Final Report - Corrections Required **Application No. SUBD-26-0037**

Description : Single Family residential north of New Life Drive in the Flying Horse Masterplan.

Document Filename : FP Creekridge at Flying Horse Filing No. 1 26 0504.pdf

SHEET 1 OF 6
APRIL 23, 2026
JOB NO. 1171.78
CREEKRIDGE FILING NO. 1

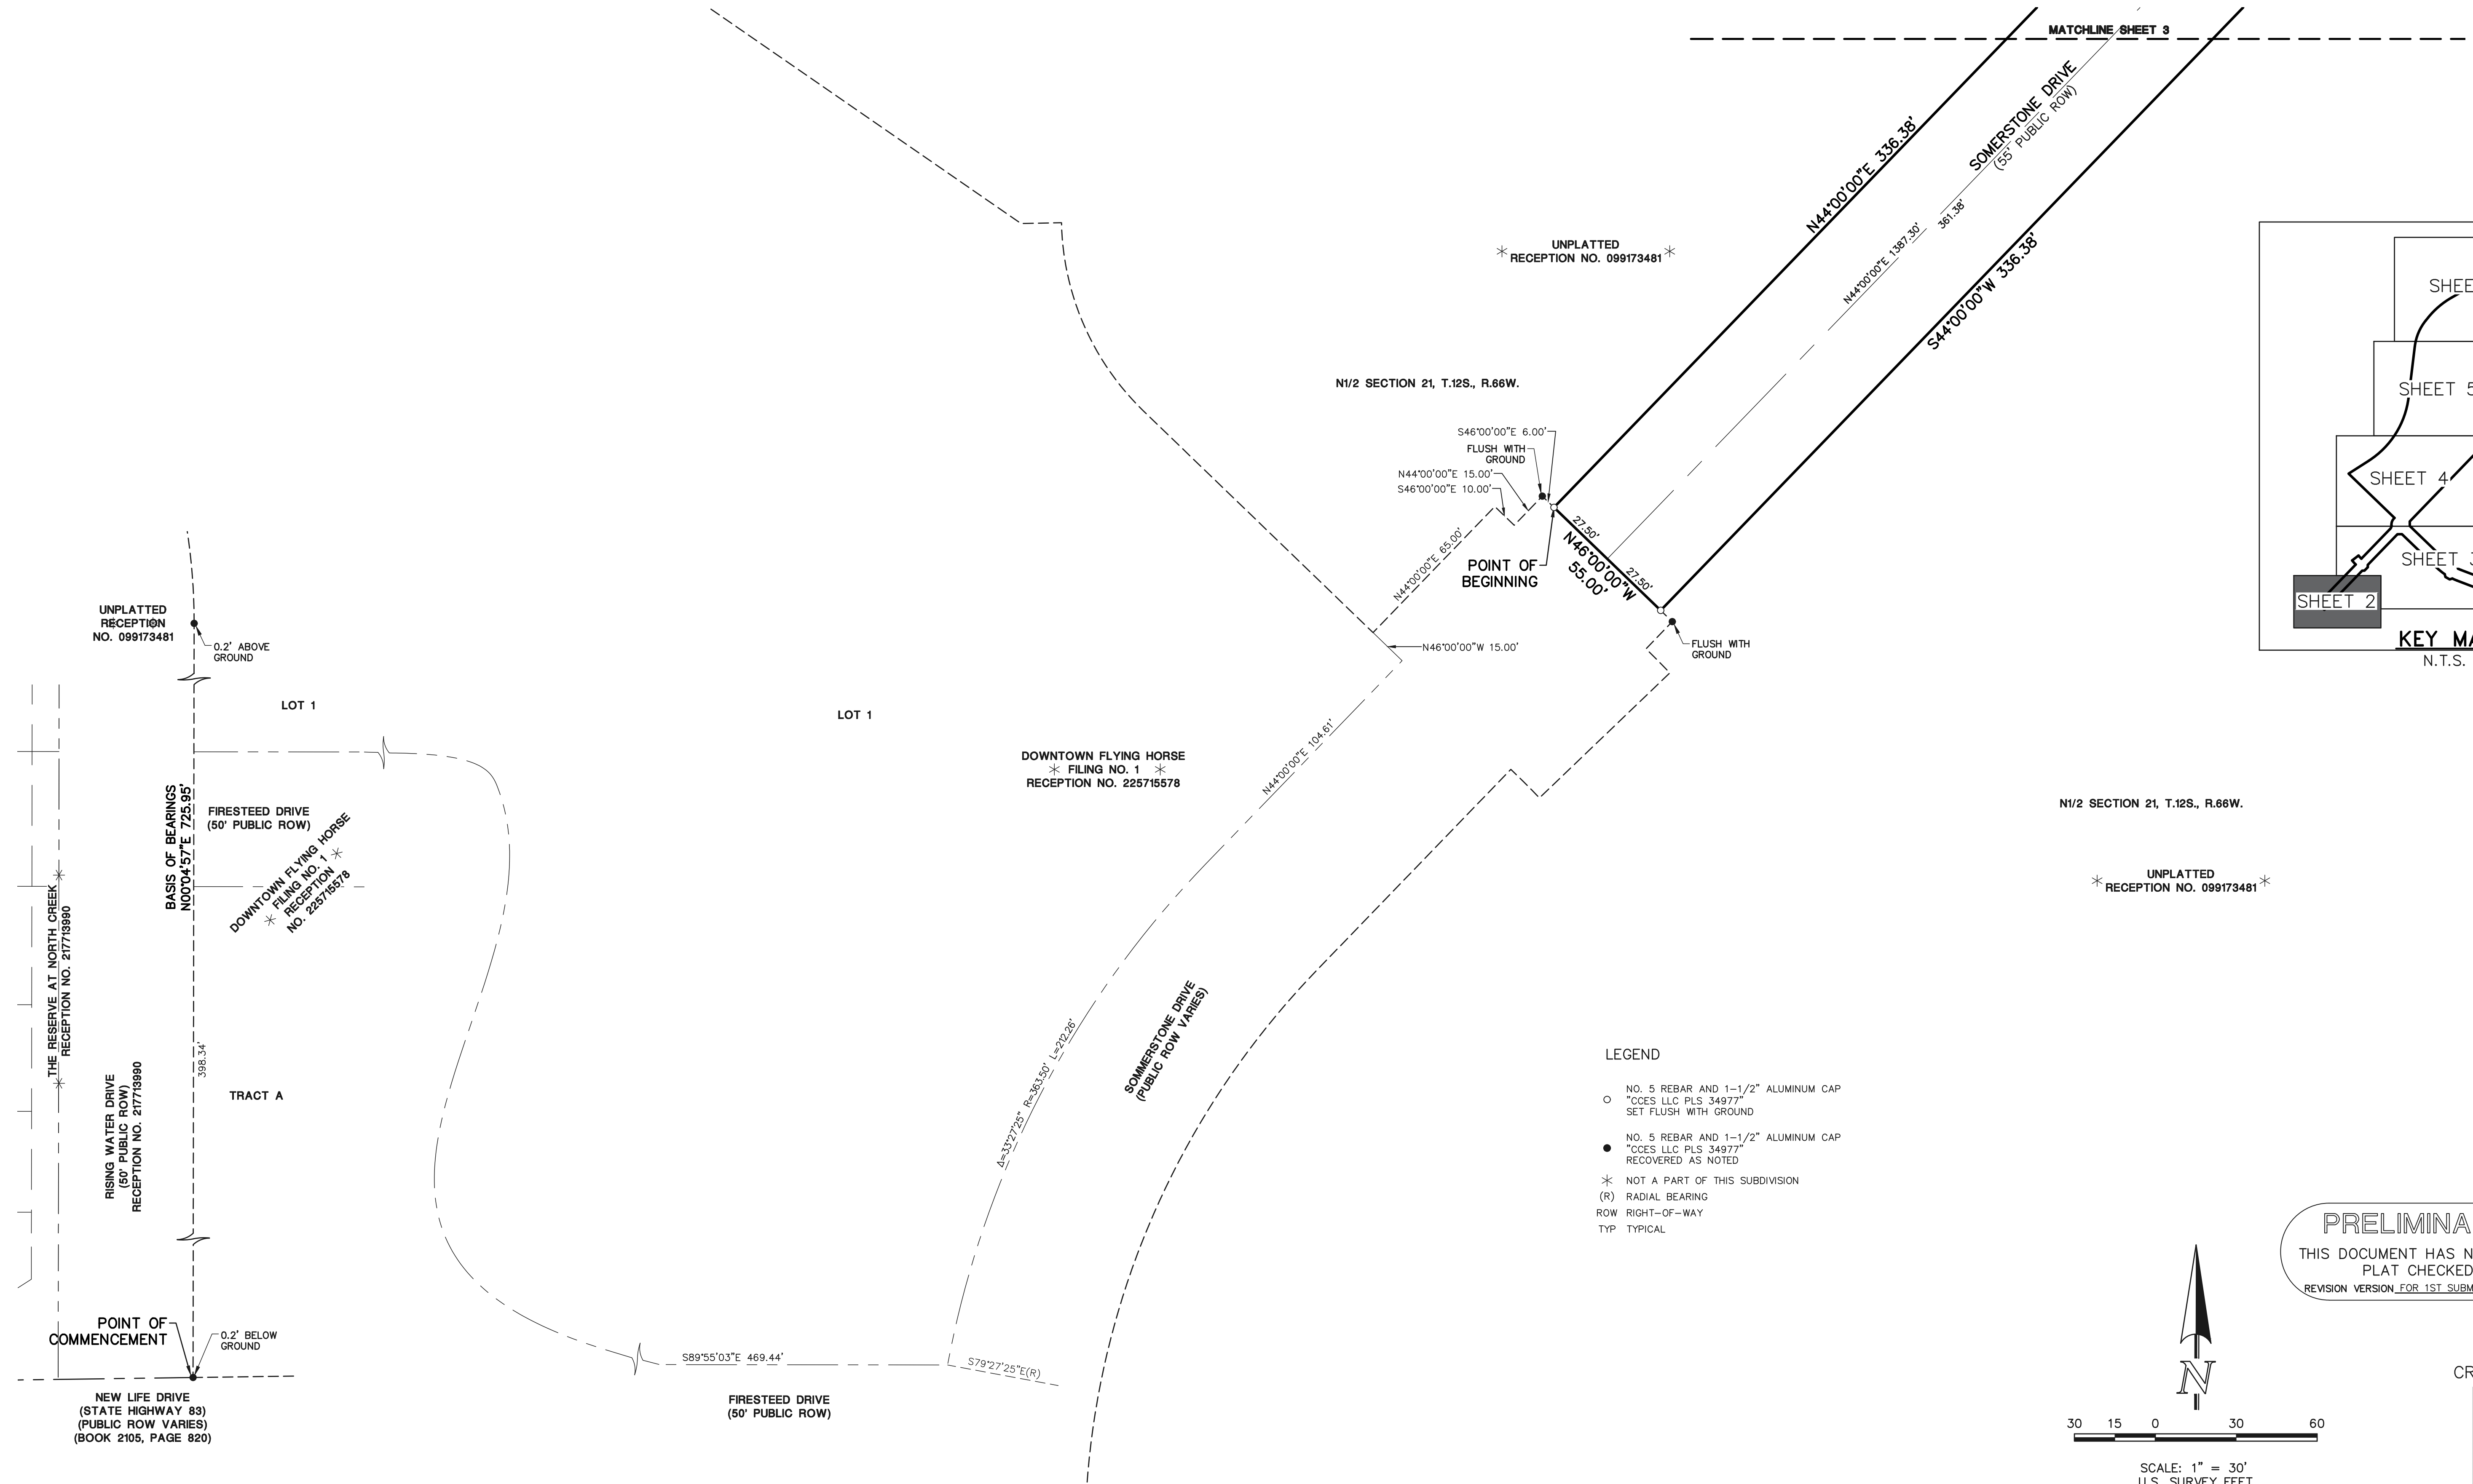
Comment ID	Page Reference	Reviewer : Department	Review Comments
3	1	Barbara Reinardy : Real Estate Services	On all sheets: SUBD-26-0037
4	3	Barbara Reinardy : Real Estate Services	Please explain the purpose(s) of a private use easement. Would one interfere with a public utility easement? Please note that private easements cannot be dedicated by plat, and can only be granted by a separately recorded easement document.
5	3	Barbara Reinardy : Real Estate Services	Please include "P.U.E." in your legend, or spell it out in each Easement Detail.
8	3	Barbara Reinardy : Real Estate Services	To vacate a public easement(s), please refer to Real Estate Services' website at coloradosprings.gov/Departments/Real Estate Services , for a current Public Application Form and Instructions regarding the process. For questions, contact Barbara Reinardy, 719-385-5601, or Barbara.Reinardy@coloradosprings.gov . To submit your paperwork: 30 S. Nevada Ave., Ste. 502, Colorado Springs, CO 80903. Allow a minimum of 4-6 weeks for processing.

On all sheets: SUBD-26-0037

SHEET 2 OF 6
APRIL 23, 2026
JOB NO. 1171.78
CREEKRIDGE FILING NO. 1

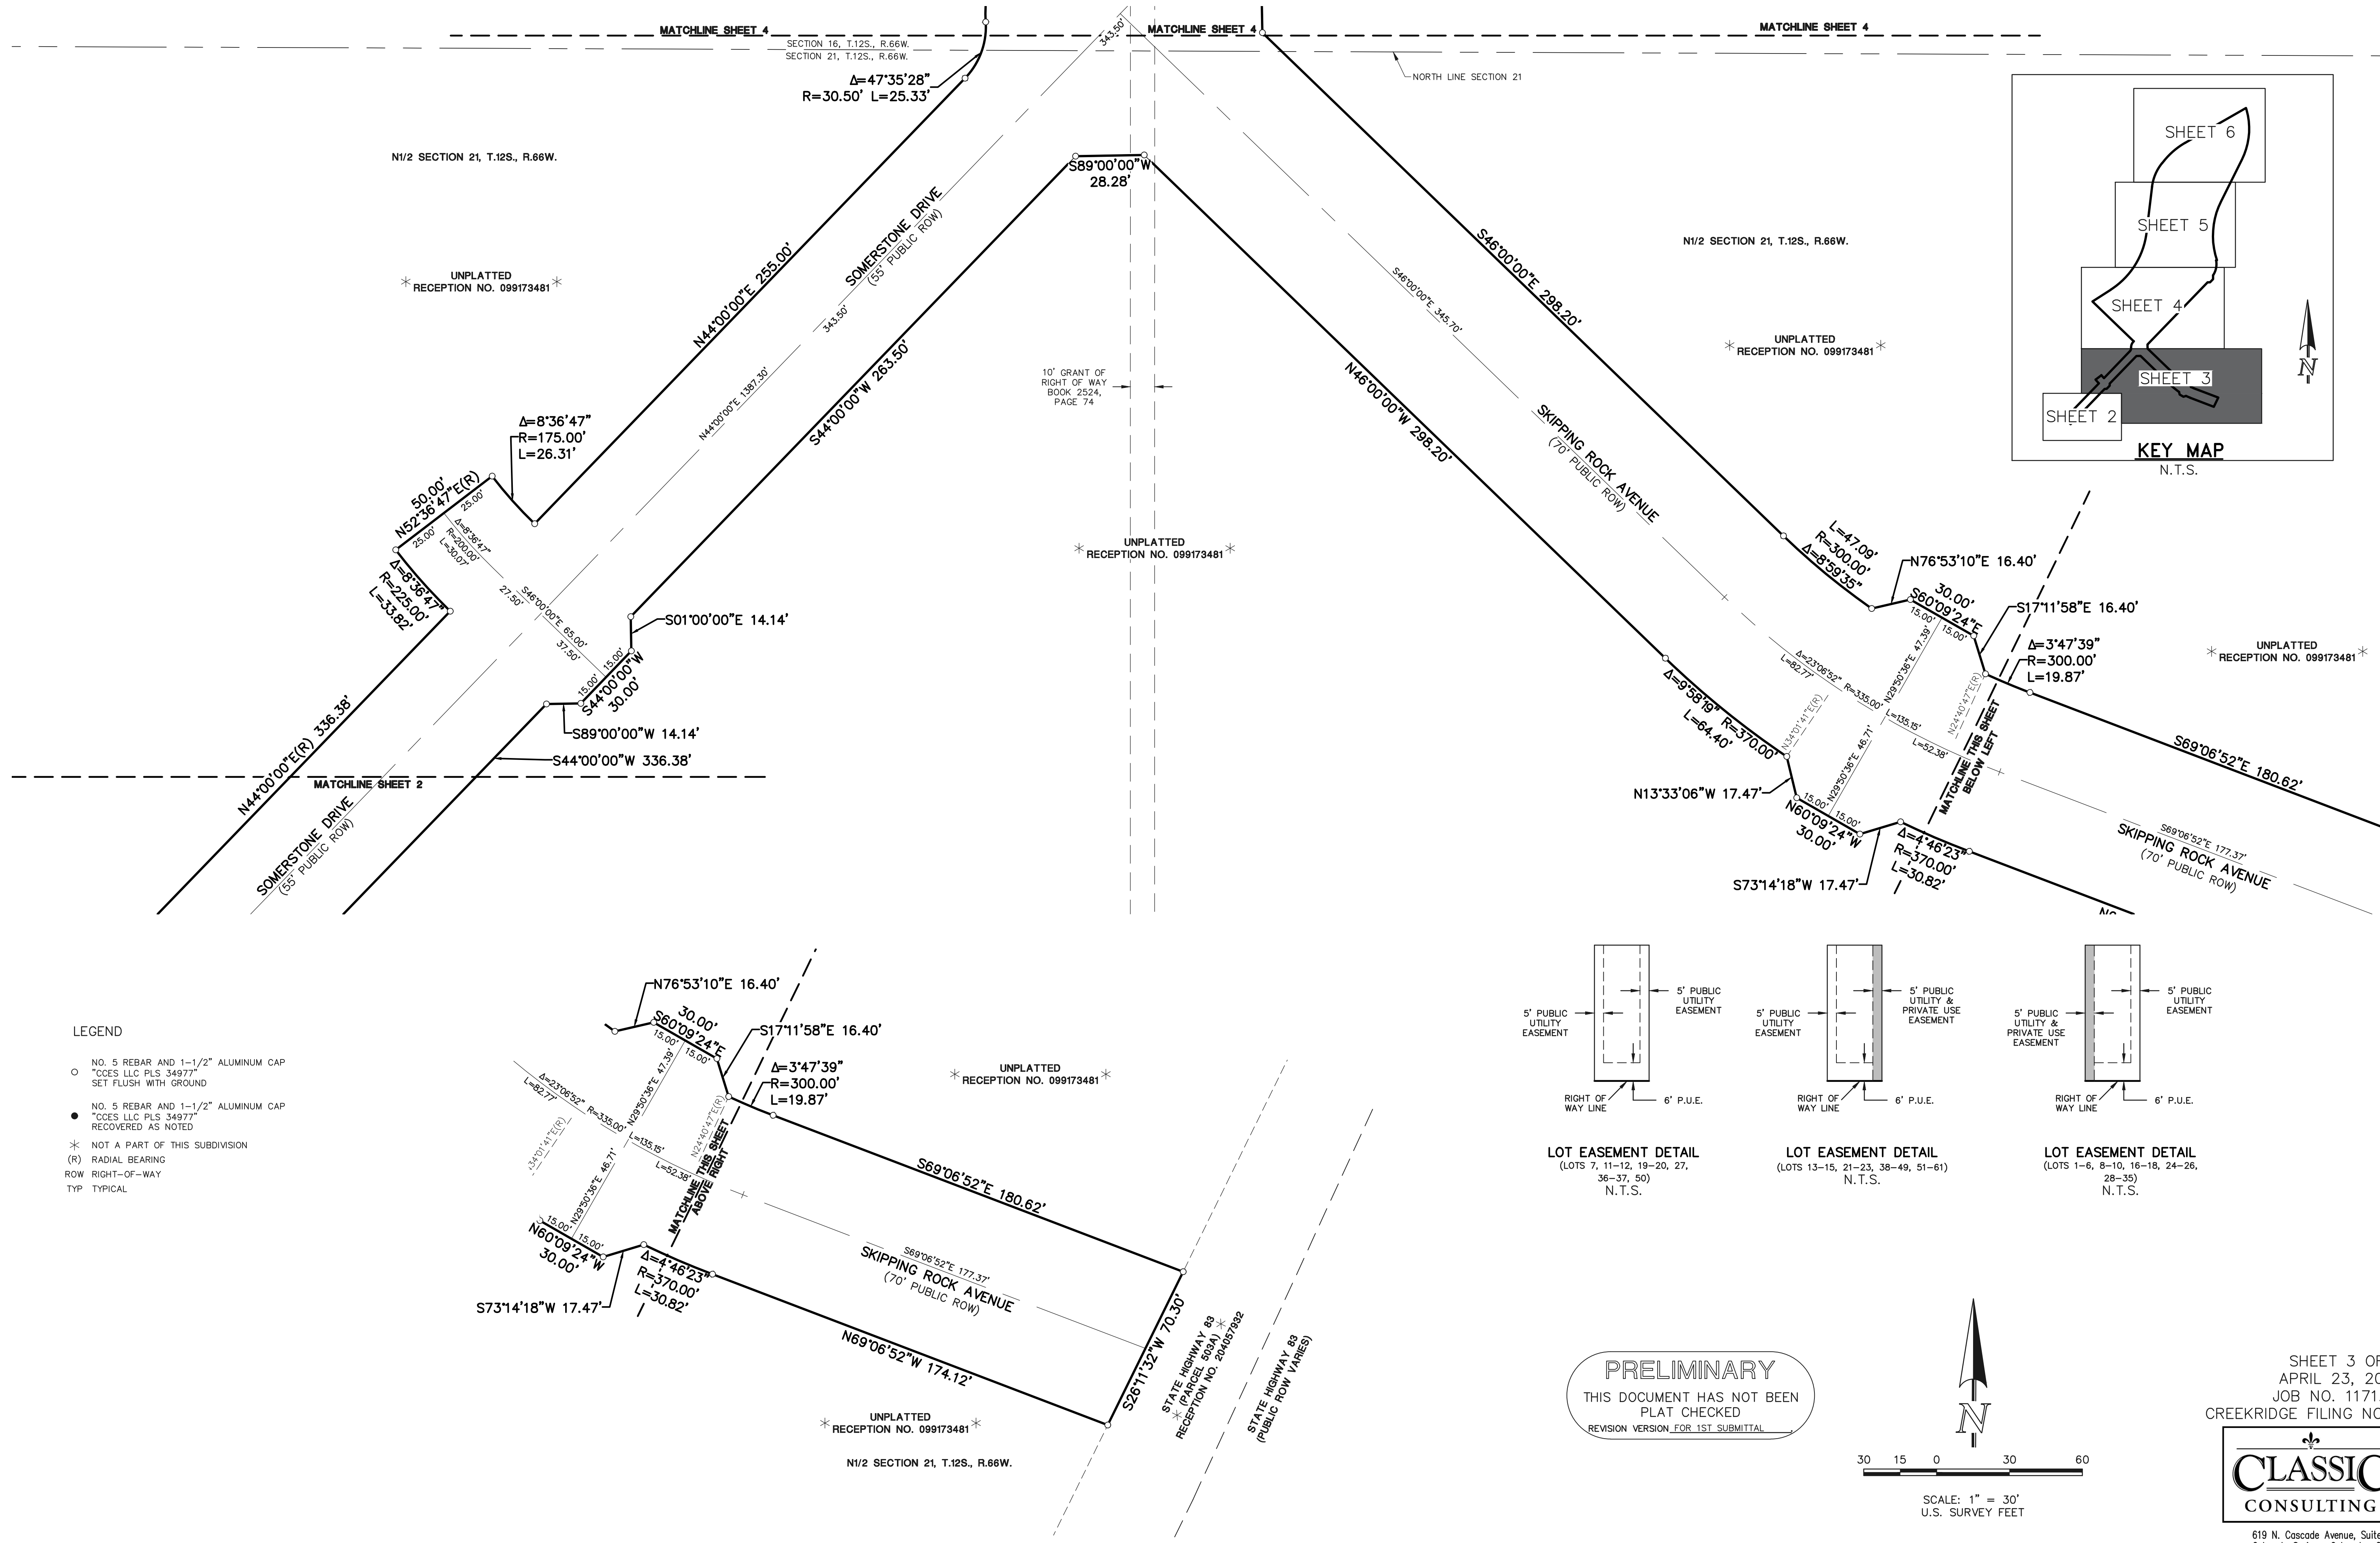
31	1	Allison Stocker : Planning	Please verify that the lot sizes shown on the related DP match the plat. There are a few minor discrepancies/typos.
13	2	Michelle Lavelle : Planning	Street naming - Street names spelled correctly and appropriate use of suffixes.
15	2	Cory Sharp : Planning	per the basis of bearings statement this is a PLS 30118 please revise accordingly
17	2	Cory Sharp : Planning	platted distance is 398.35' is it a rounding difference
12	4	Cory Sharp : Planning	when will this easement be vacated as it will encumber several lots and streets
2	1	Barbara Reinardy : Real Estate Services	You can remove the lines for the signer's name and title, as they are already included.

per the basis of bearings statement this is a PLS 30118 please revise accordingly

platted distance is 398.55' is it a rounding difference
